Sent: 15 July 2010 14:40
To: Planning
Subject: Comments Added: W WATERS & SONS LTD, HARPSFIELD BROADWAY, HATFIELD

Application Details:
Application ID: S6/2010/1169/AD - MISS J PHILLIPS Application Owner: Welwyn & Hatfield Borough Council (Development Control Officer)
Applicant: MK MARKING SYSTEMS
Location: W WATERS & SONS LTD, HARPSFIELD BROADWAY, HATFIELD Deadline Date: 02/07/2010 00:00:00
Description: Erection of two hoarding signs, one double sided post mounted and one single sided wall mounted

A. 1no. DOUBLE SIDED TIMBER FRAMED PLYWOOD HOARDING MOUNTED ON STEEL POSTS  
 TIMBER FRAME AND POSTS PAINTED BLACK, PLYWOOD PAINTED GLOSS WHITE.  
 GRAPHICS WILL COMPRISE PRINTED POSTERS APPLIED TO FACE OF HOARDING.  
 POSTERS WILL CHANGE. (EXAMPLE SHOWS TYPICAL MOTOR TRADE POSTER)

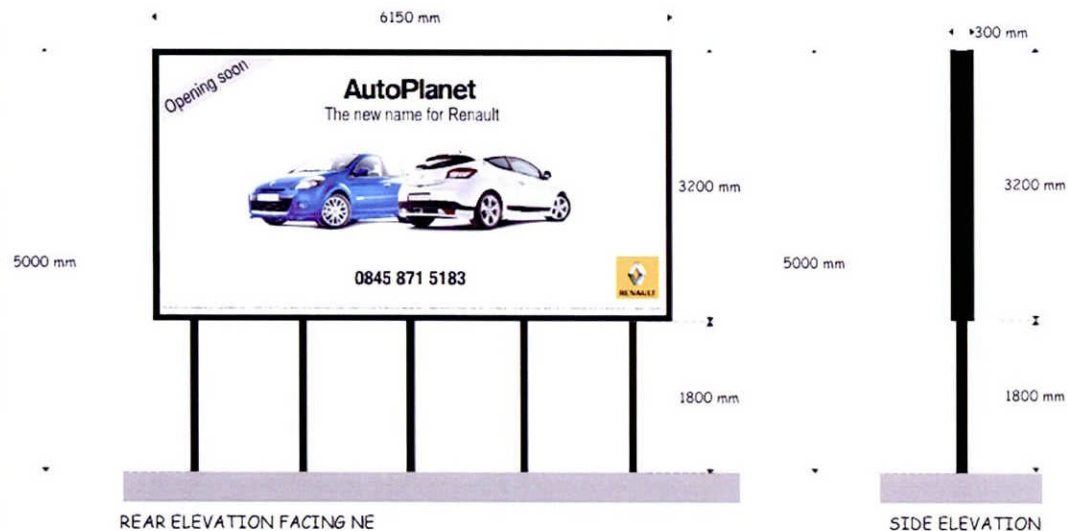
Commented By: hatfieldtown@aol.com
Comment: The Town Council object to the size of the hoardings considering both to be a distraction to road users.
